RE: REQUEST FOR ADVICE - INTEGRATED OILSEED PROCESSING PLANT (MP07_0146-MOD-8)

Wagga Wagga City Council (Council) welcomes the opportunity to comment on the Request for Advice - Integrated Oilseed Processing Plant (Mp07_0146-Mod-8) publicly exhibited from 2 October to 15 October 2025.

Figure 4 | Trahairs Road and Byrnes Road / Trahairs Road Intersection

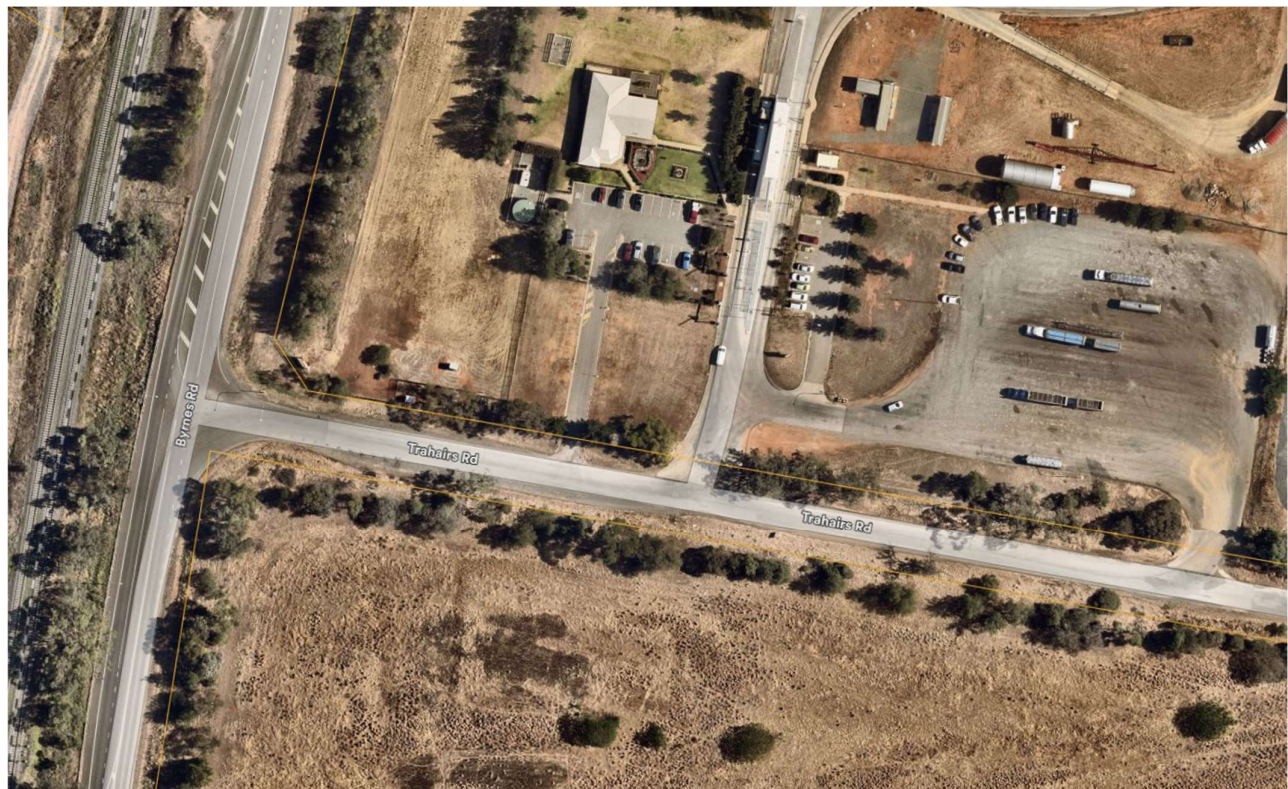
Byrnes Road is a sub arterial road that has been developed and classified to cater for this kind of industrial development with large numbers of heavy vehicle movements. Trahairs Road is a local road and is currently in poor condition. As per previous modifications and consultation, consideration should be given to the additional impacts of reducing the pavement design life of Trahairs Road.

ROBE is the only significant heavy vehicle traffic generator on Trahairs Road. Accordingly, any upgrades required to ensure that the residual design life of this road is not reduced due to increased loading and/or AB-Triple crossover movements, should be conditioned unless the Applicant can demonstrate that the impacts of the proposed modification are insignificant and further road deterioration will not occur.

The Applicant must ensure that Trahairs Road, between the site entrance and Byrnes Road (including the intersection with Byrnes Road), is upgraded to the satisfaction of Council, prior to the commencement of operations, with all costs to be borne by the Applicant.
